Frodsham Solar

Statement of Common Ground with Cheshire West and Chester Council (CWCC)

PINS Ref: EN010153

Document Ref: EN010153/DR/8.16

Figure Title **Public Rights of Way - Closures and Diversions - Section 2: Frodsham RB103, Section 3: Frodsham RB98**

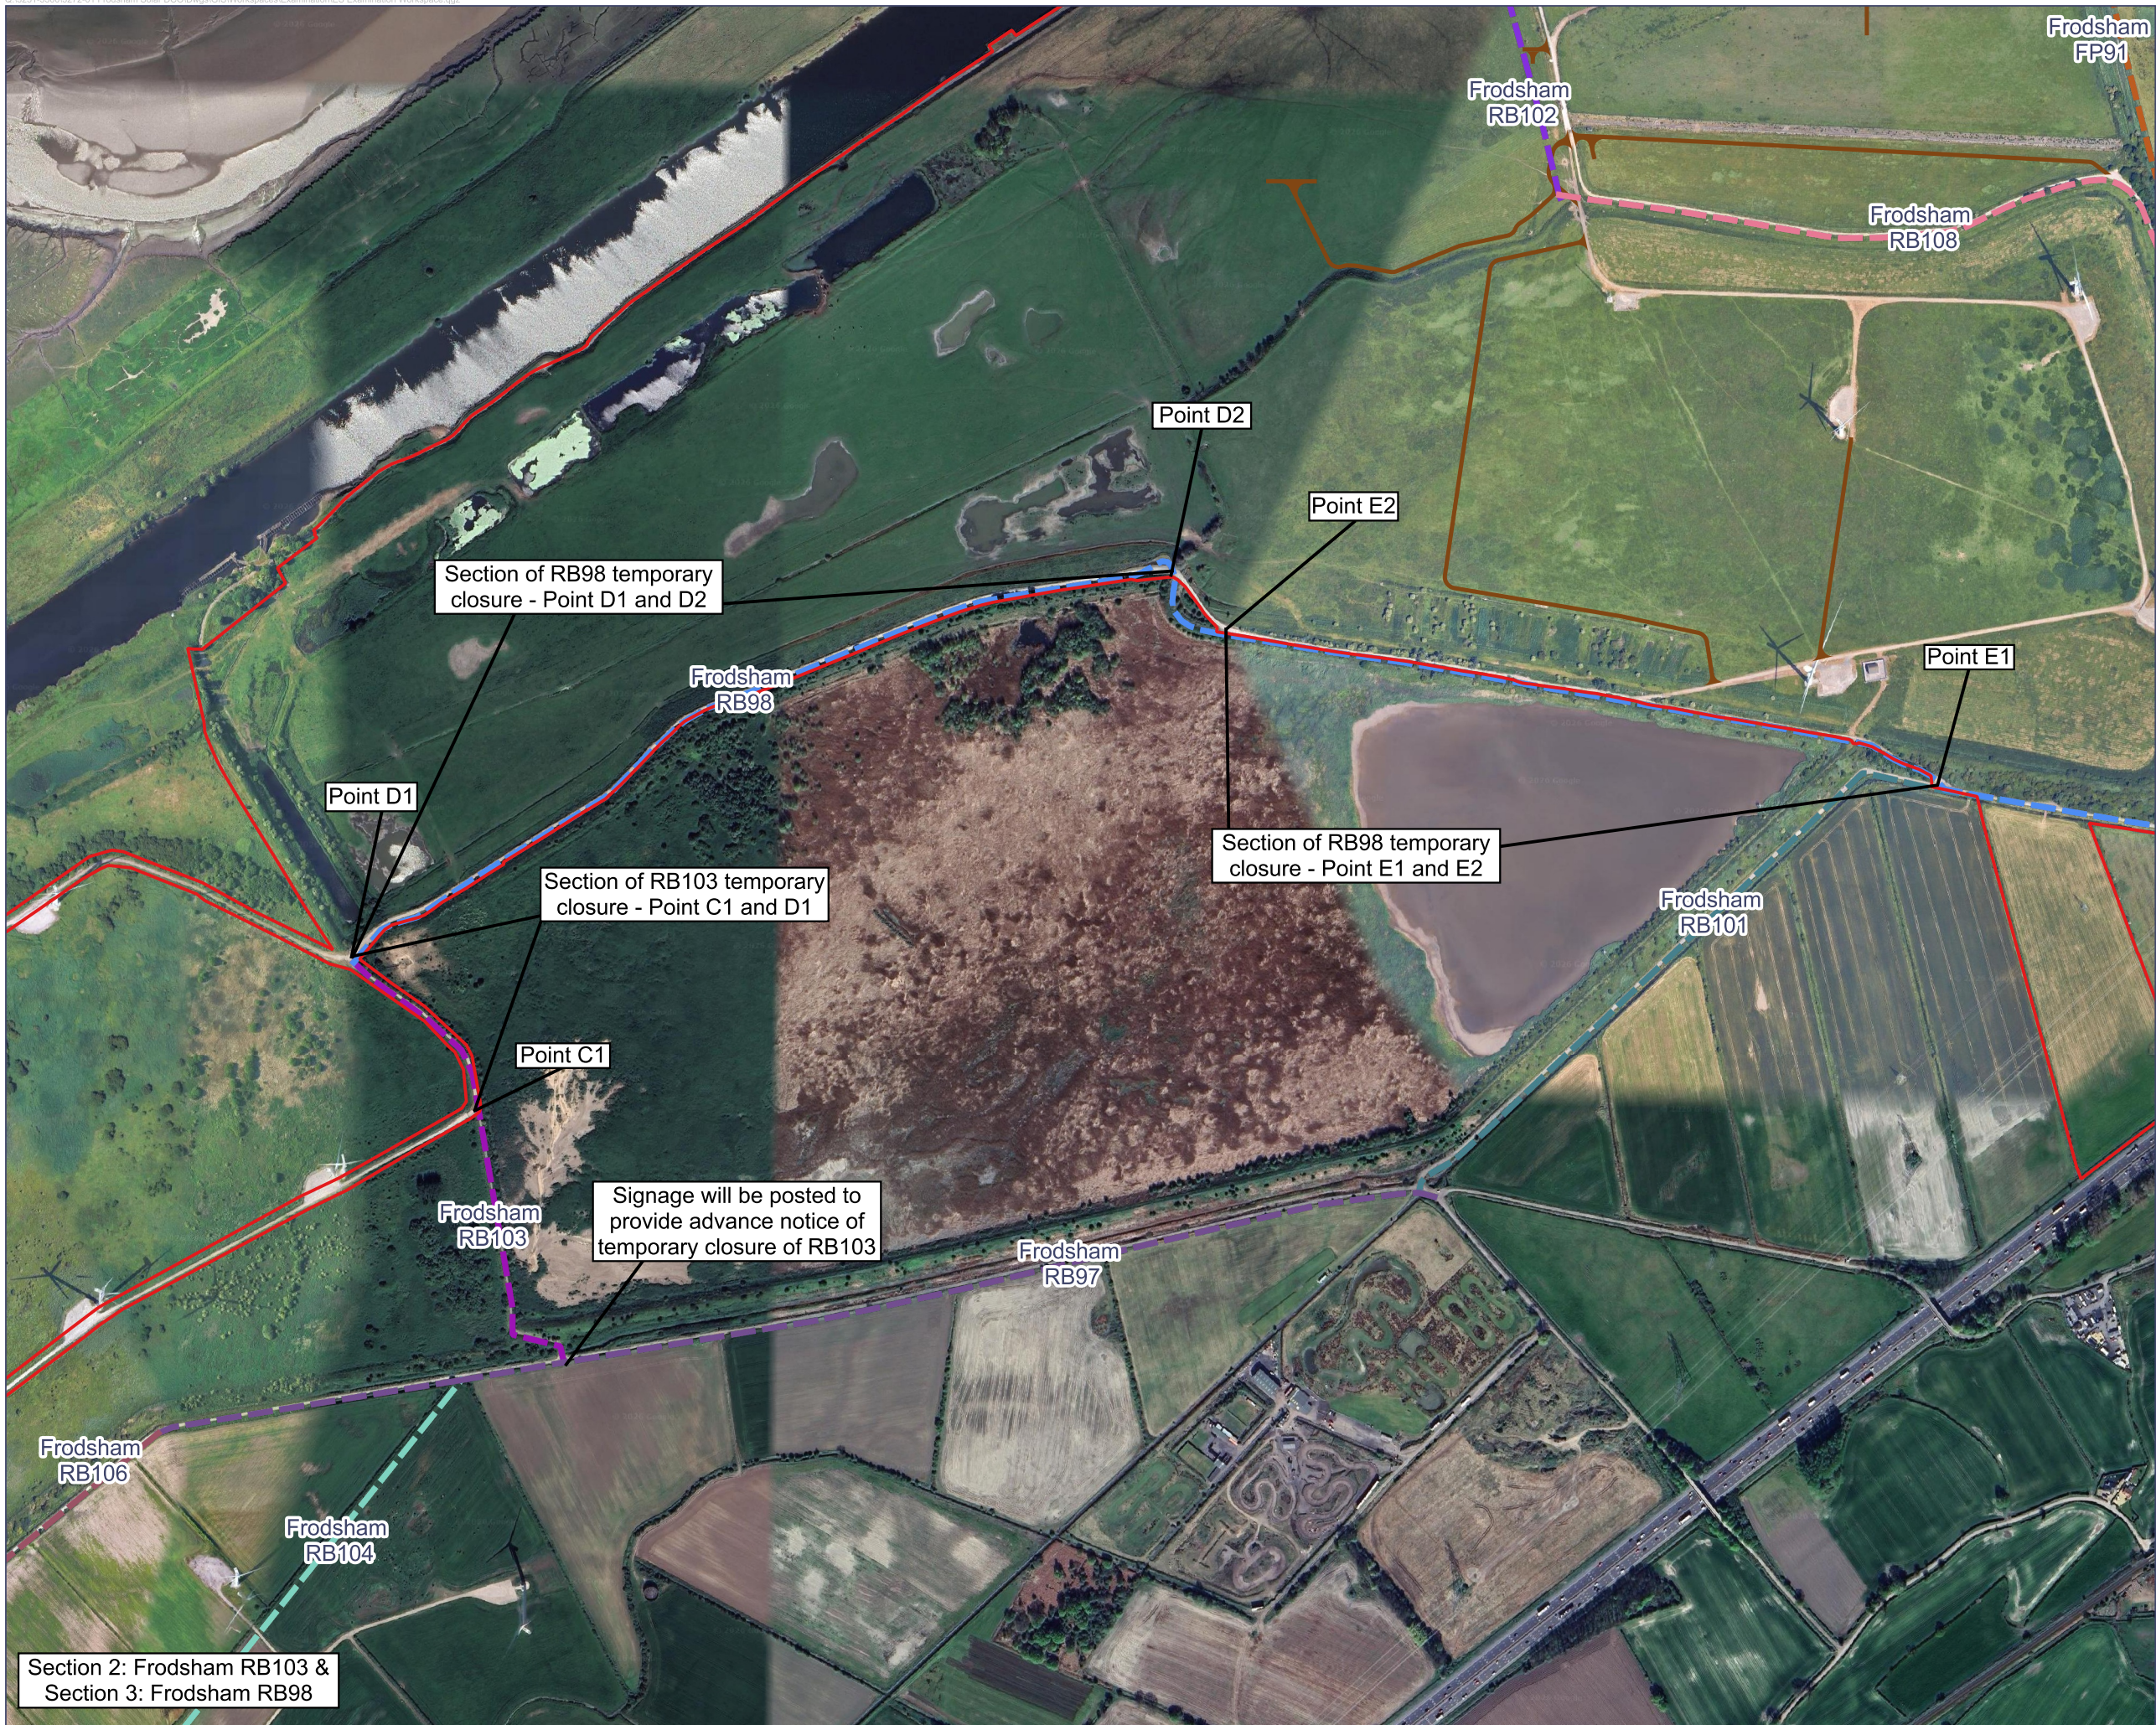
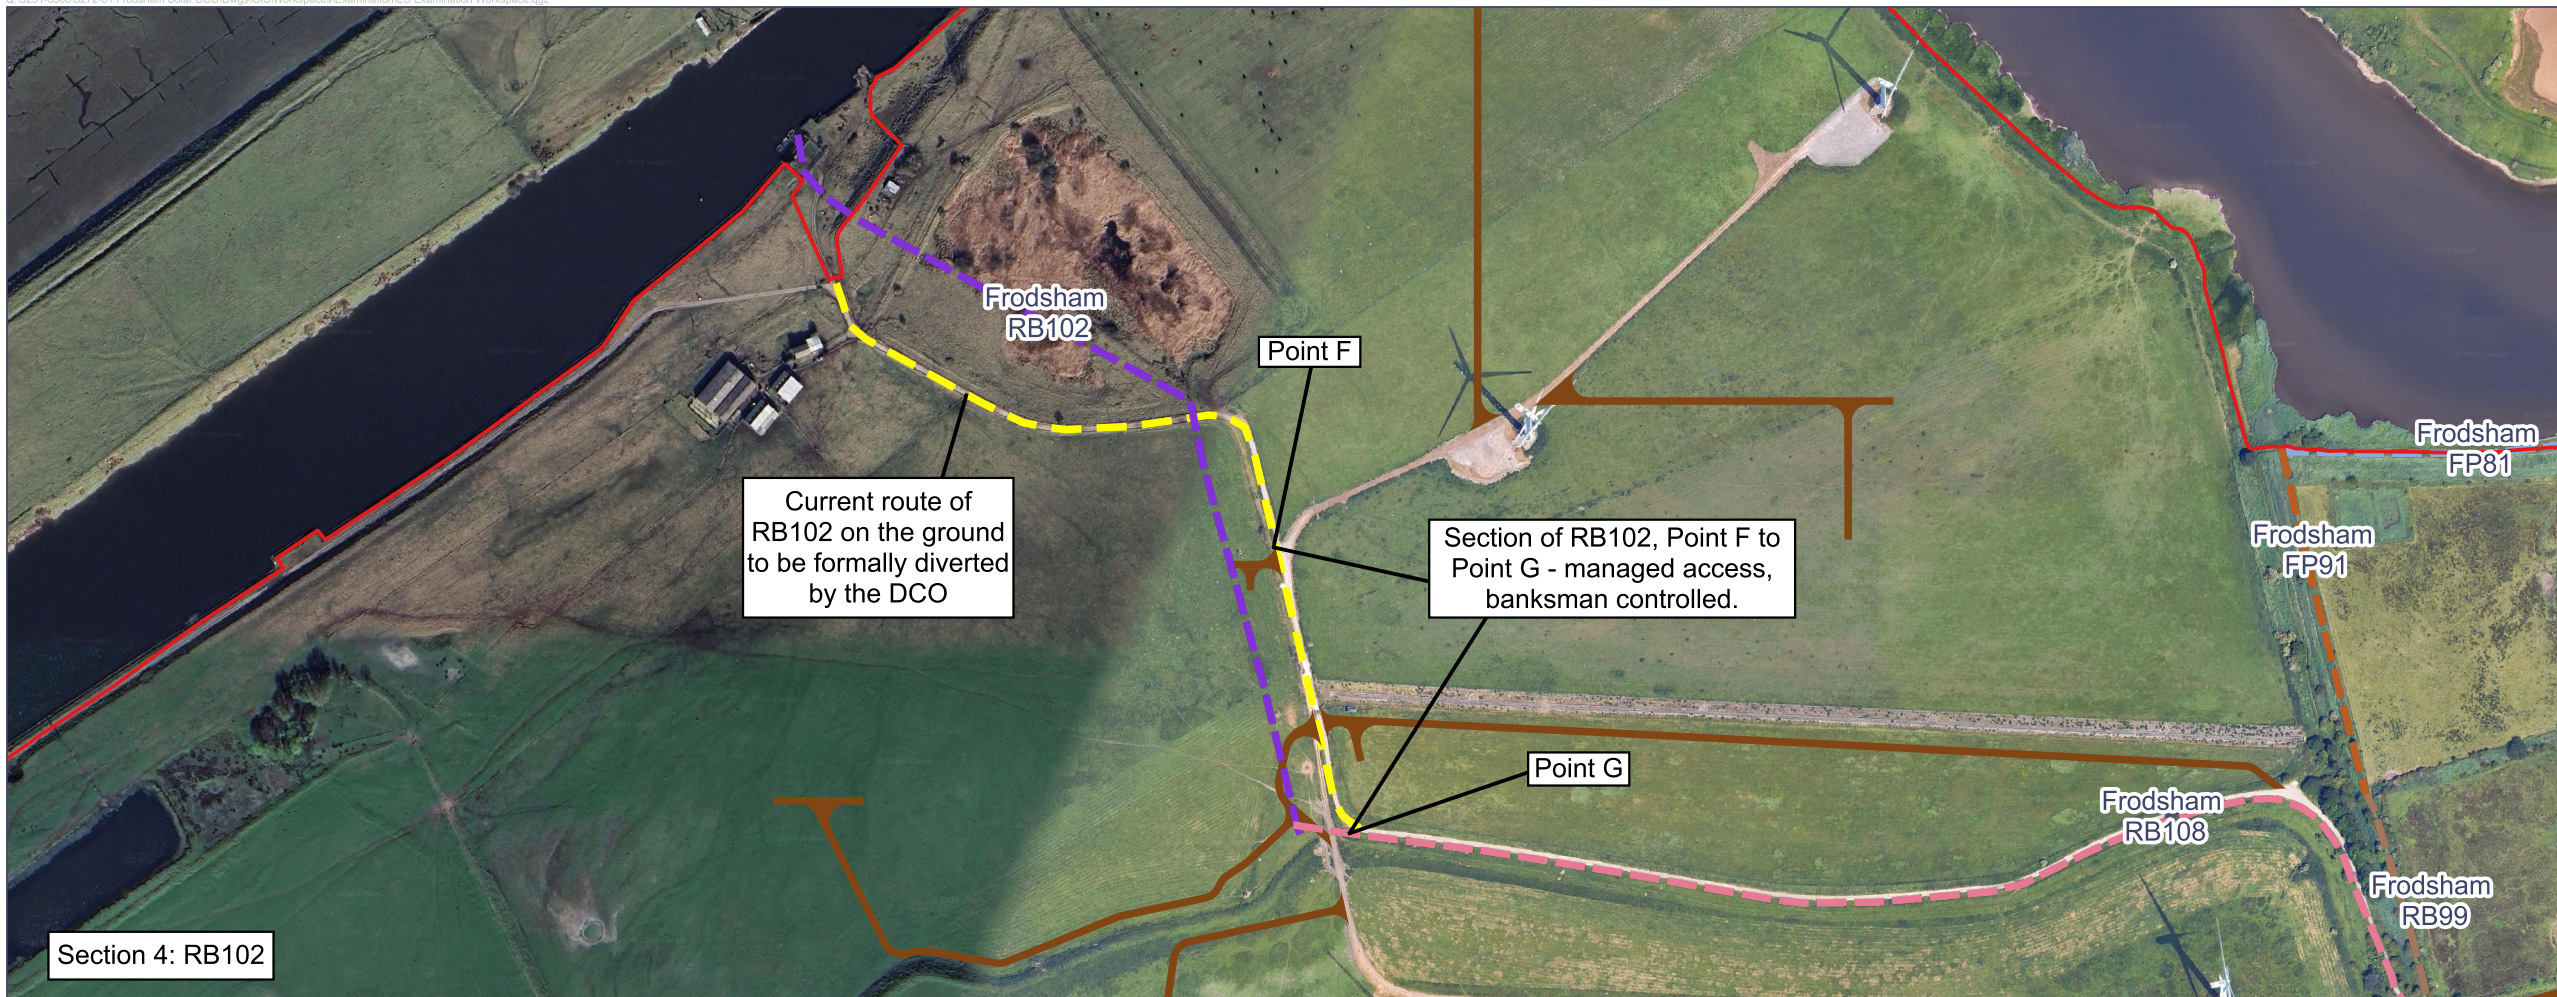
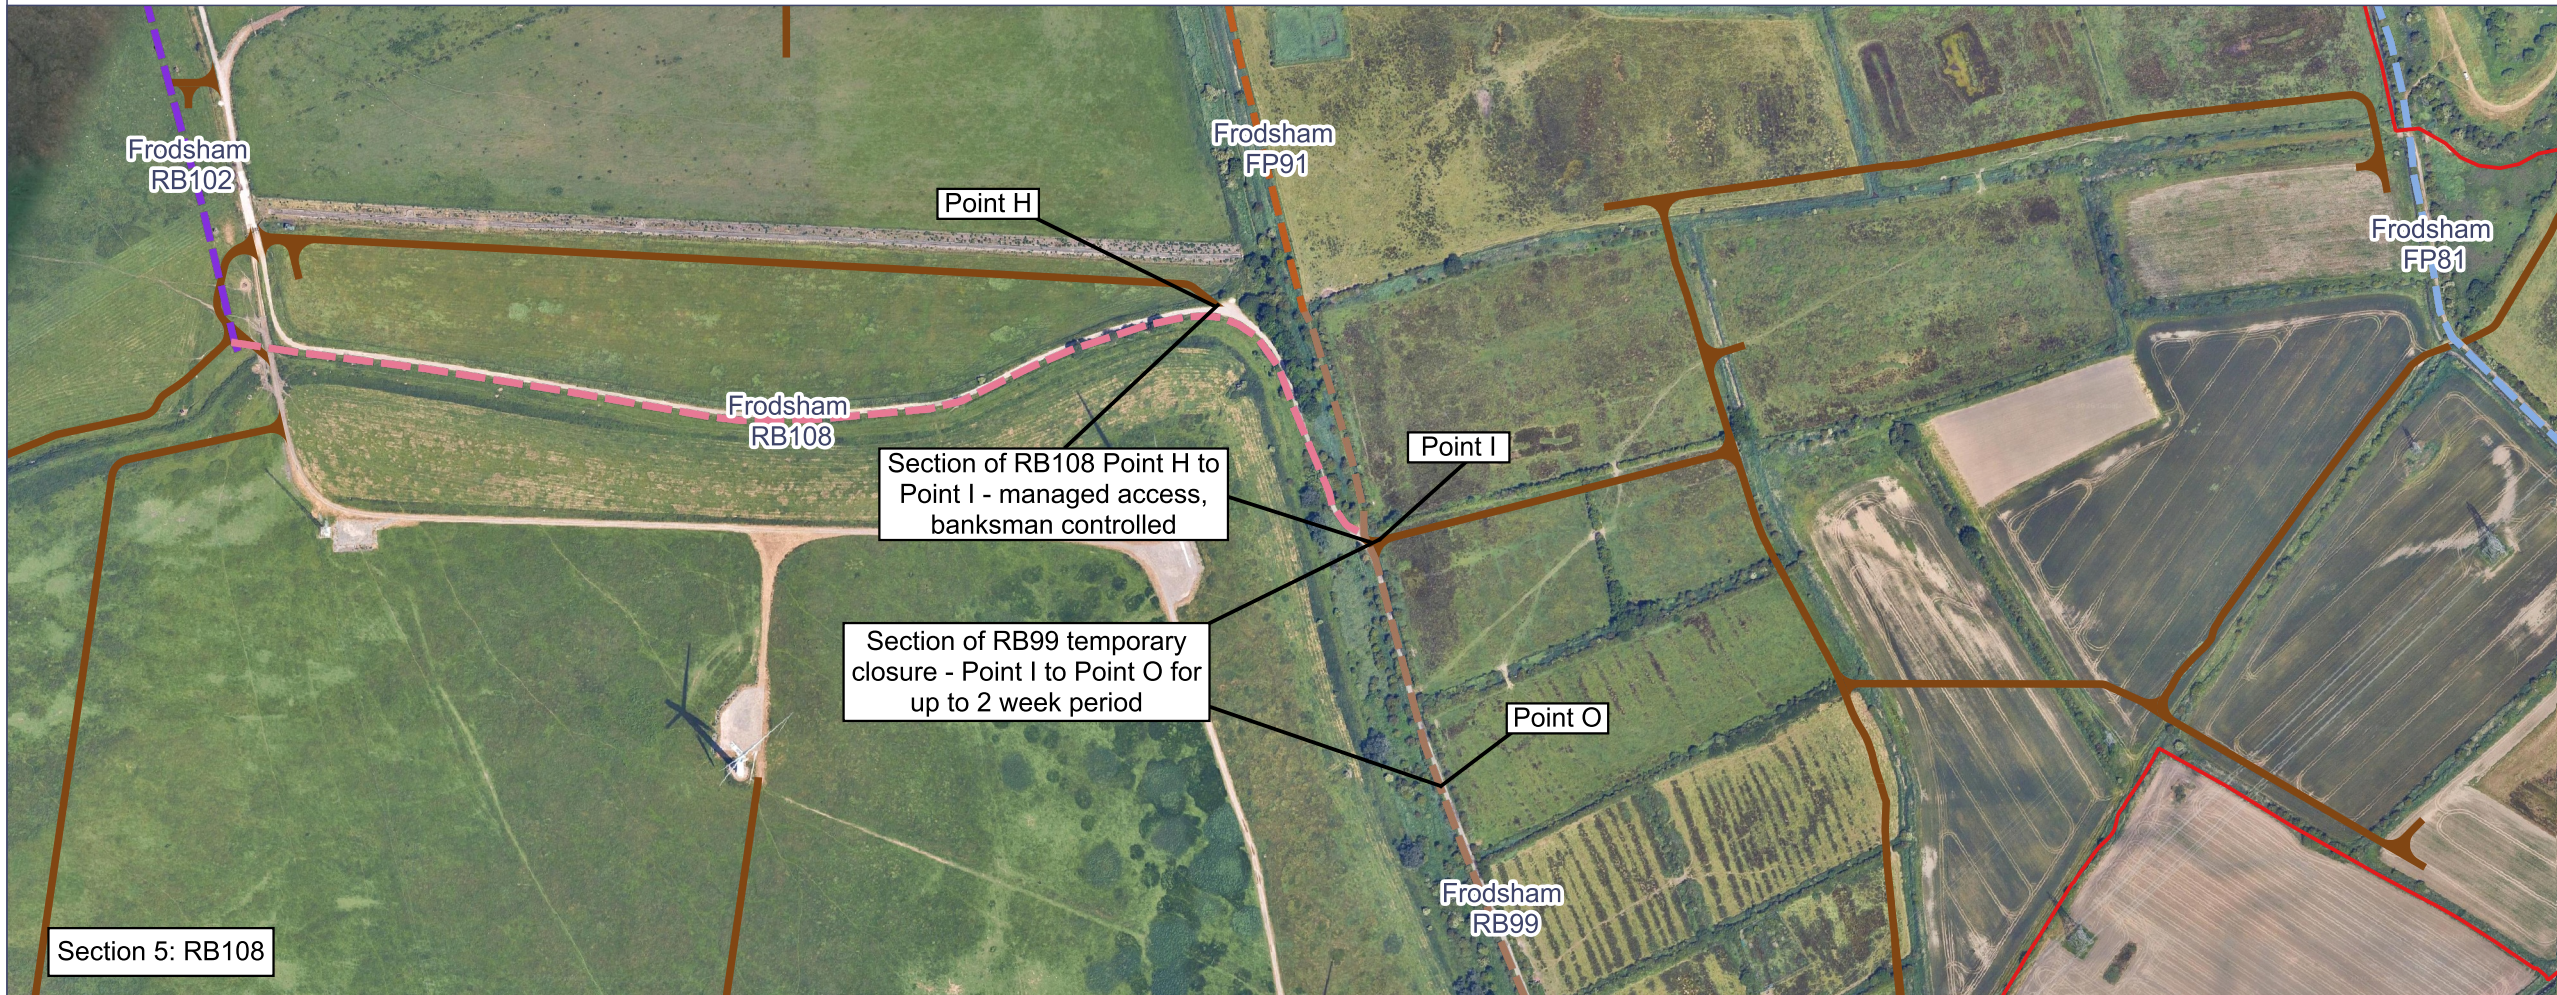
Ref.	Matter	CWCC Position	Applicant Position	Status
		<ul style="list-style-type: none"> Outline Battery Safety Management Plan P04 (REP5-027) 		
2.4.	Outline Construction Traffic Management Plan - P05 (REP4-024)	<p>CWCC welcomes the introduction of the PRoW figures as requested.</p> <p>CWCC understood that all construction traffic would access the site via Pool Lane, and at REP5-048 sought minor amendment to the routing image 4.1 to refer to the red route shown on the figures as 'Route Unsuitable for HGV and Construction traffic, i.e. not just HGV).</p> <p>The applicant has indicated that not all construction traffic would be restricted, e.g. Operatives vehicles and mini-bus may use the red route via Frodsham. This is a concern in terms of likely volume of such traffic (e.g, the main construction car parks provide over 200 spaces (paragraph 4.3.4 of oCTMP)</p>	<p>The CTMP and Transport Assessment have been clear that HGV access would be restricted from travelling along the A56 via Frodsham. Cars and minibuses have not been excluded as operatives may be living or be accommodated in premises along the A56, with Frodsham and Helsby railway stations a likely pick-up point for staff minibuses. The oCTMP has been updated at Deadline 7 to confirm that no construction vehicles HGVs or staff transport, would be permitted to access the Site via Brook Furlong or Weaver Lane.</p>	<p>Matter not agreed (resolution likely with DL7 submission)</p>
